From: Simon Davis
Sent: 14 August 2020 15:08
To: Clare Bartlett [REDACTED]
Cc: Daniel Vick <Daniel.Vick@arun.gov.uk>
Subject: RE: AL/49/20/PL Byfields & Nightingale Cottage

From: Simon Davis <Simon.Davis@arun.gov.uk>
Sent: 11 August 2020 14:56
To: Clare Bartlett [REDACTED]
Subject: AL/49/20/PL Byfields & Nightingale Cottage - Design & Highways

Dwellings 3 & 6

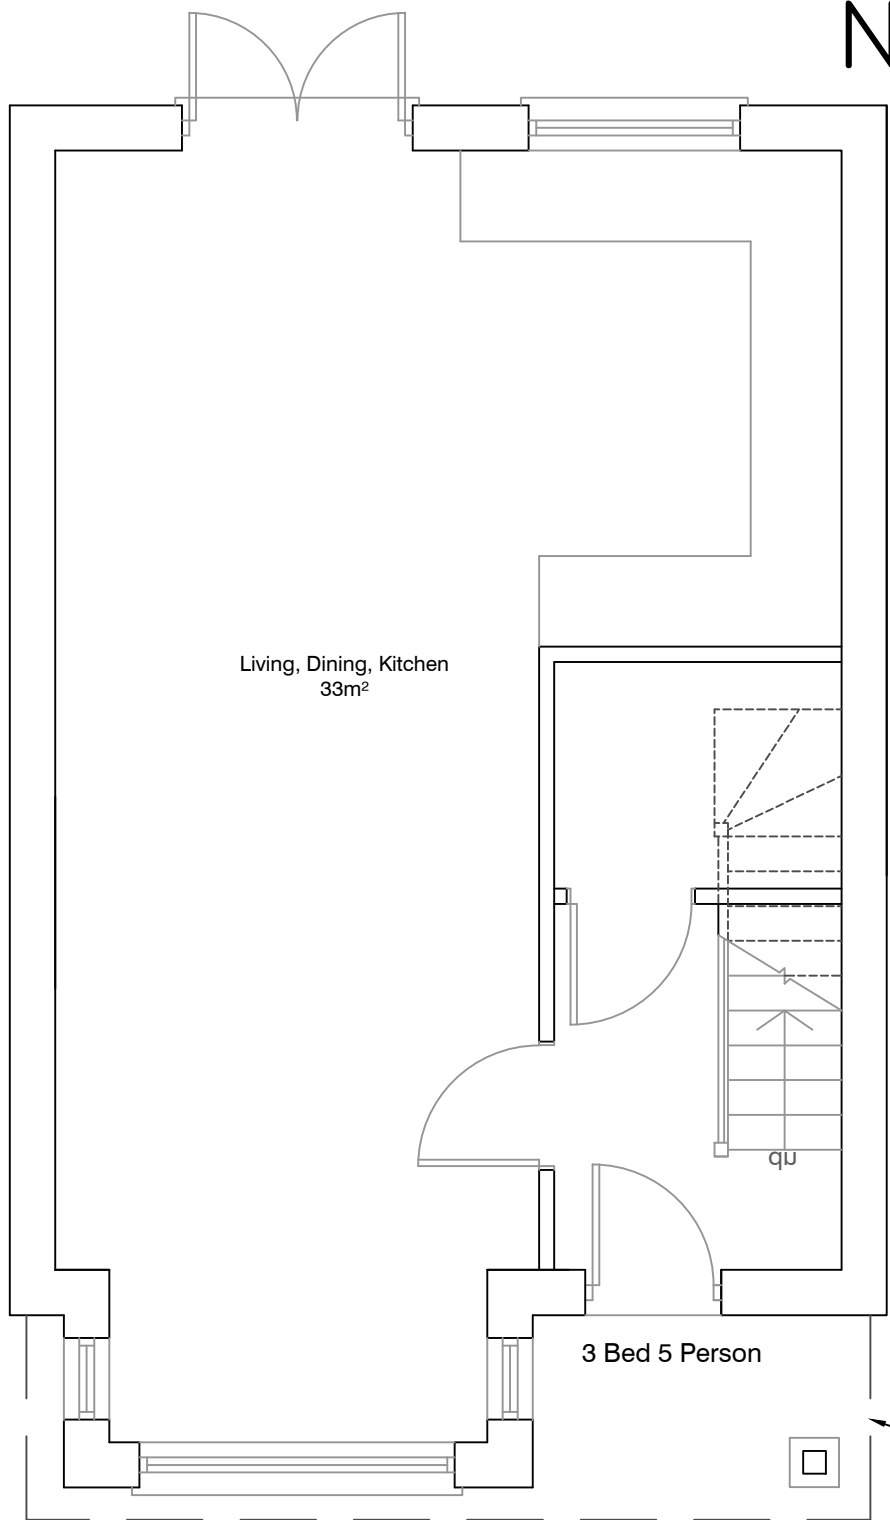
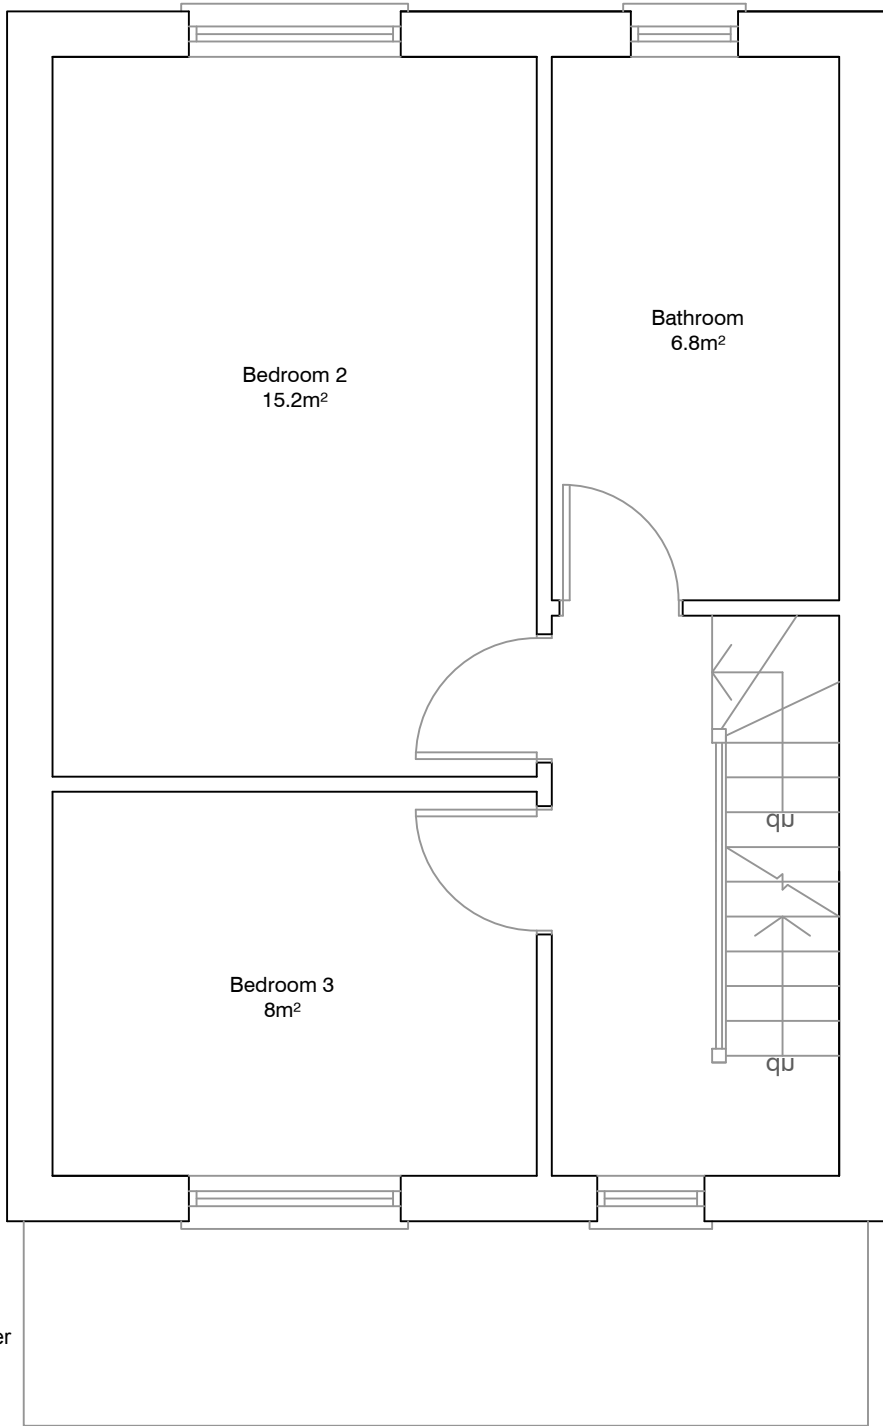
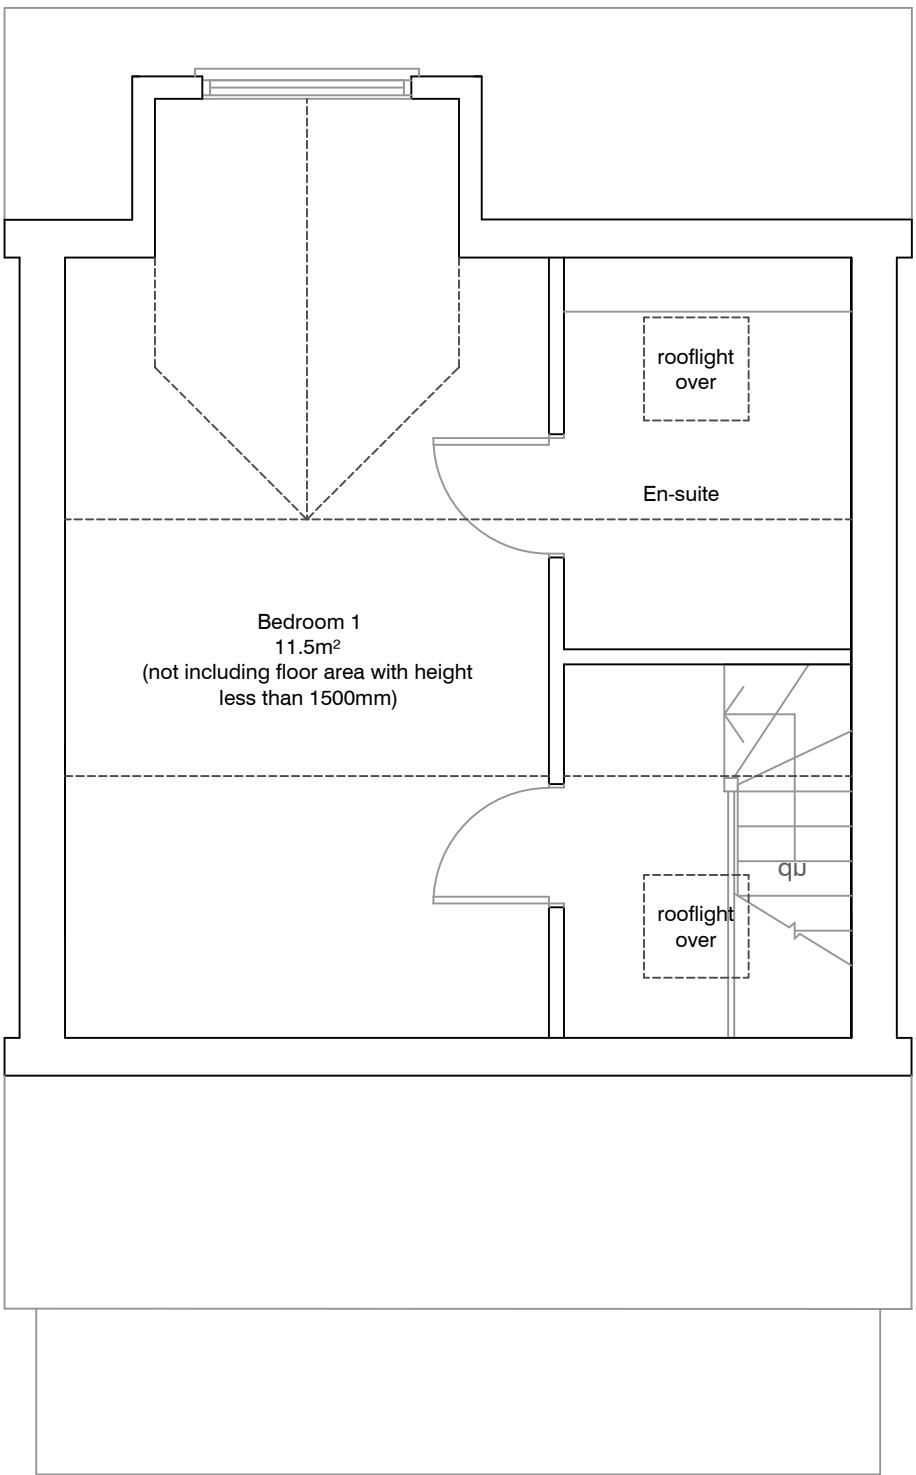
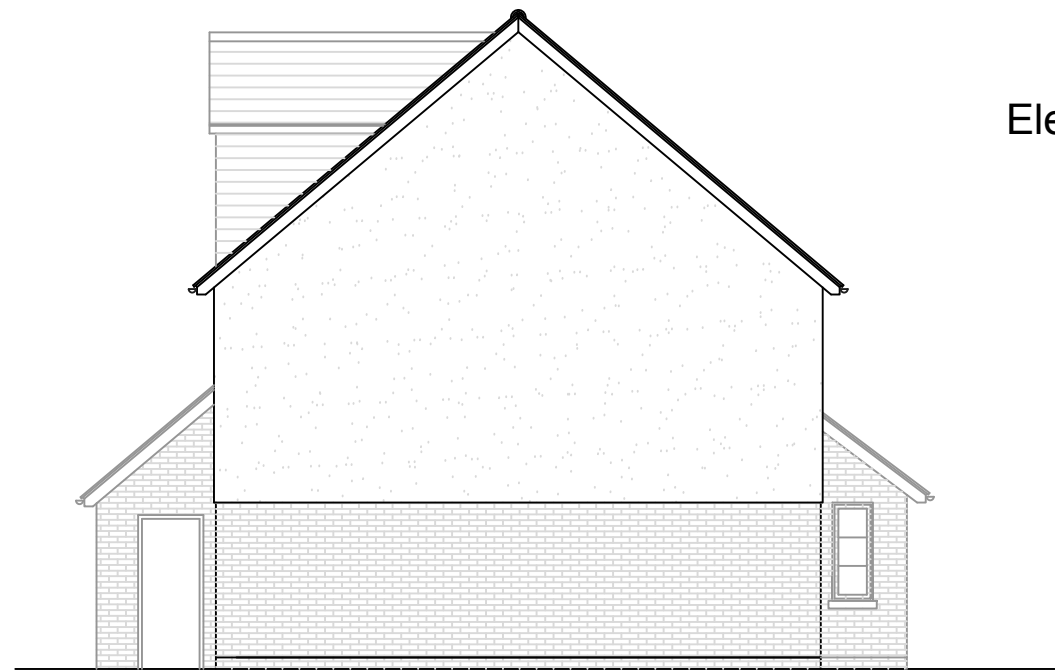
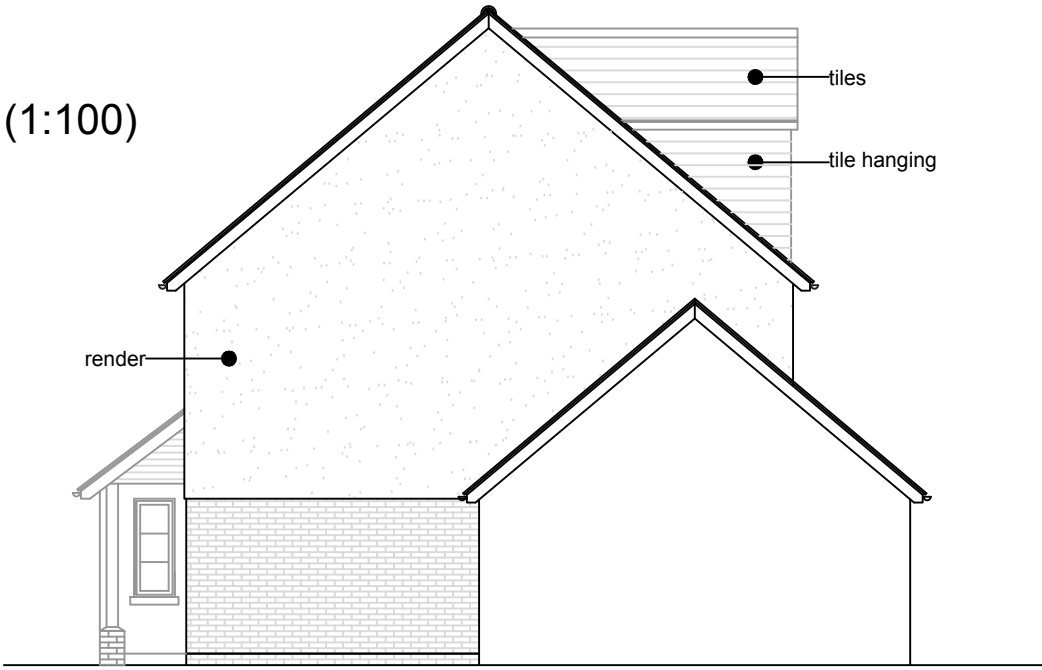
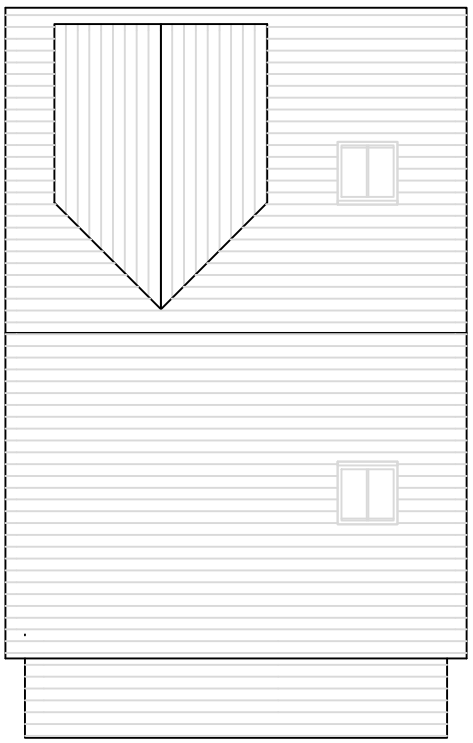
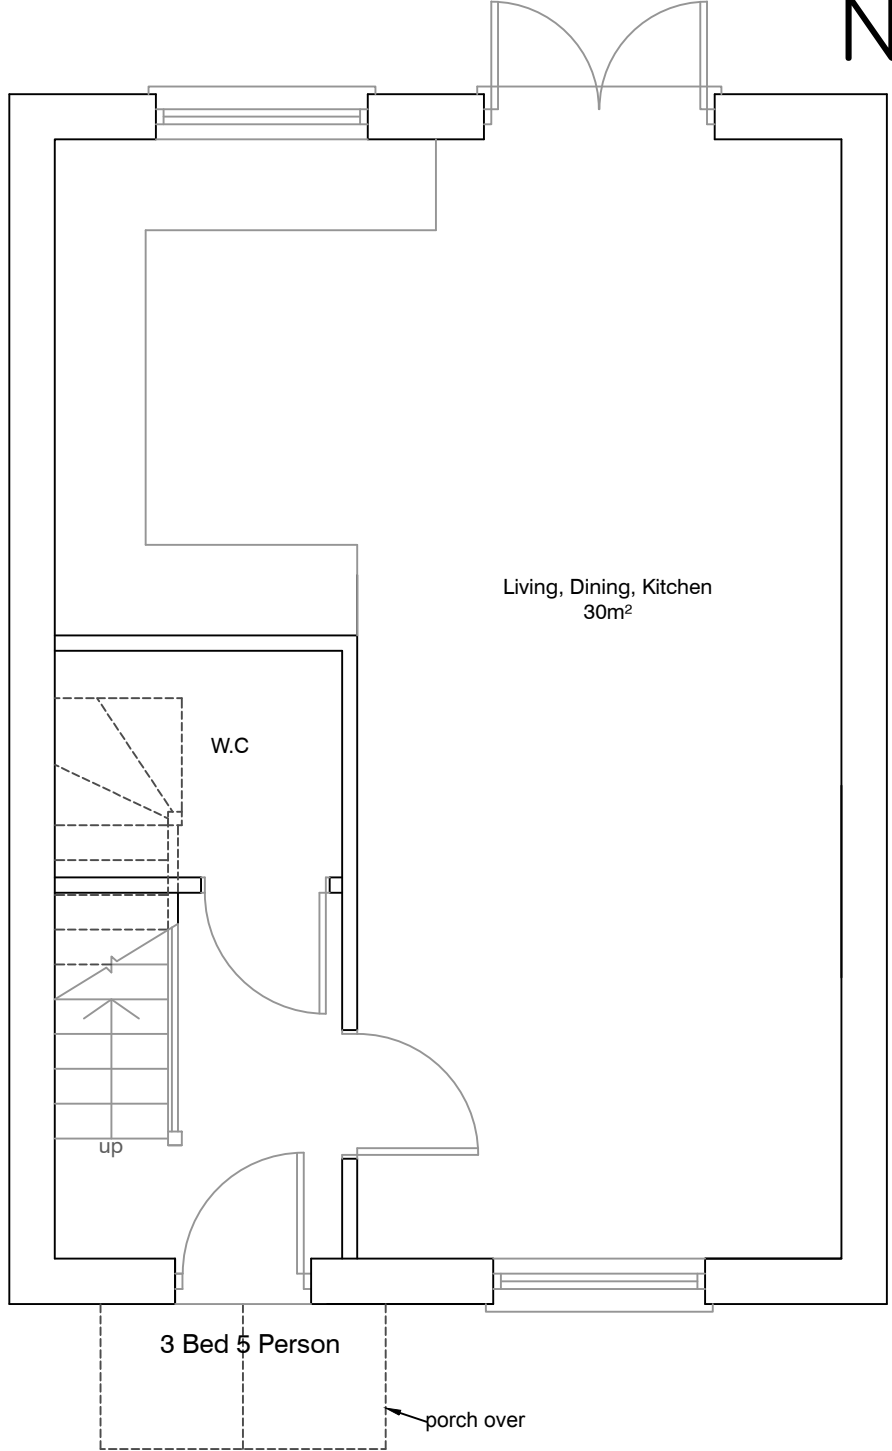
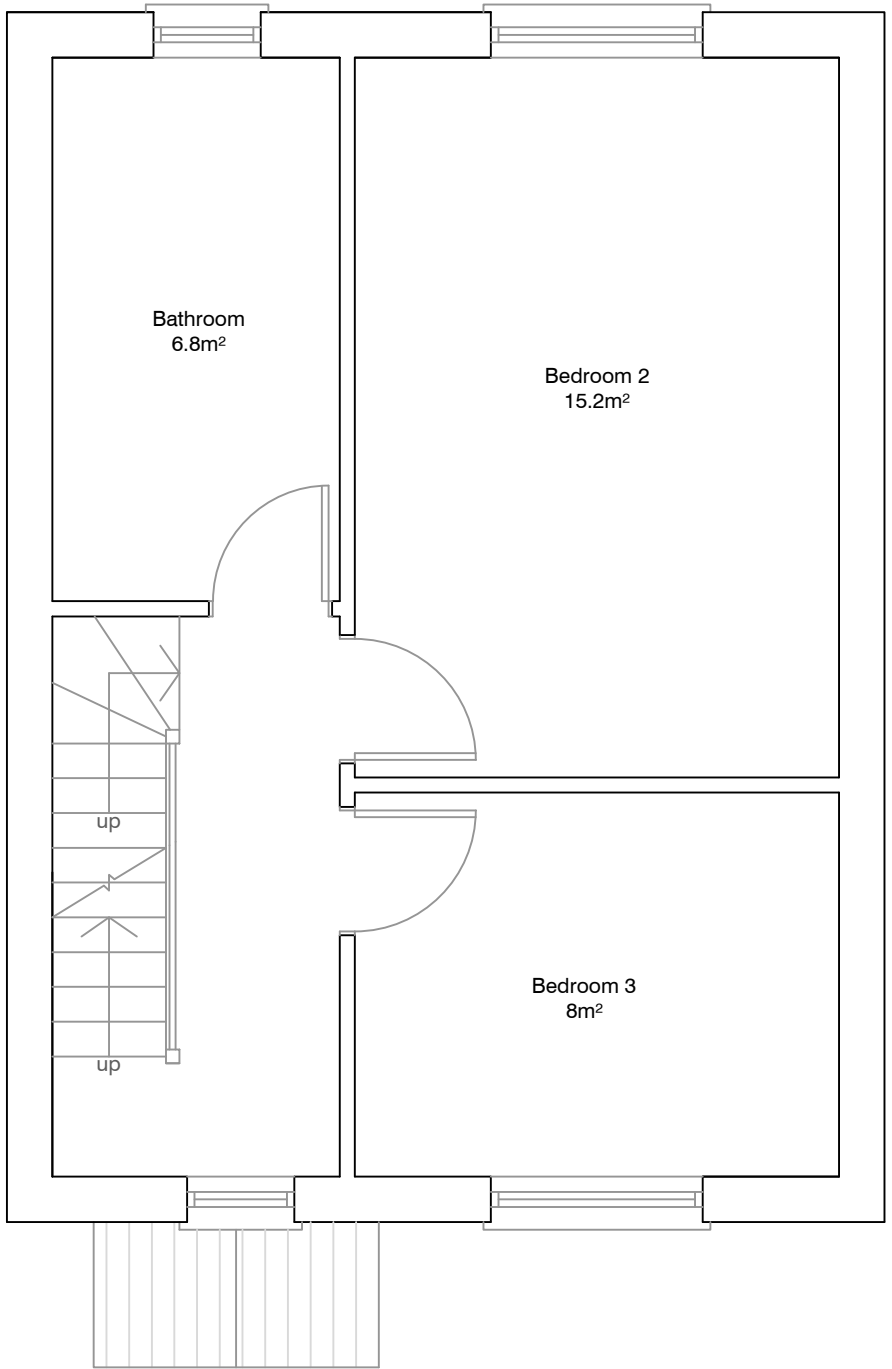
Regarding scale, notwithstanding my comments on the PreApp above, I do note that I stated in that response that whilst an element of 2 storeys would be acceptable, the overriding scale of the new dwellings should be 1.5 storeys. I accept that the dormers are to the rear elevations however the presence of the front velux's still gives a 2.5 storey impression. Also I am not convinced that the presence of what is clearly an attic window in the Old Stores establishes a 2.5 storey character.

- The site is very much of an urban/rural edge character and the proposals do not reflect this character.
- The elements that make up the character of this site – boundary wall, grass verge, landscaping, spacing will all be destroyed as a result of the proposals.
- The design is poor and does not appear to be based on local character/context. Either side of the site are dwellings with a relatively strong character, yet what is proposed is at odds with that.
- Surrounding dwellings are predominantly 1.5 storeys yet these are 2.5.
- The trees on the frontage should be respected & retained.
- There may be a scheme here but definitely not 6 dwellings.

I disagree. Only Mill View has 1.5 storeys and this is the most recent addition to the road. The established character is provided by The Old Stores which has the appearance of a 2.5 storey building, and the cottages which are 2 storeys. The proposed scheme has the appearance of 2 storeys from Nyton Road, with the use of loft space only apparent to the rear and this view is screened by trees. The height of the dwellings is also lower than The Old Stores.
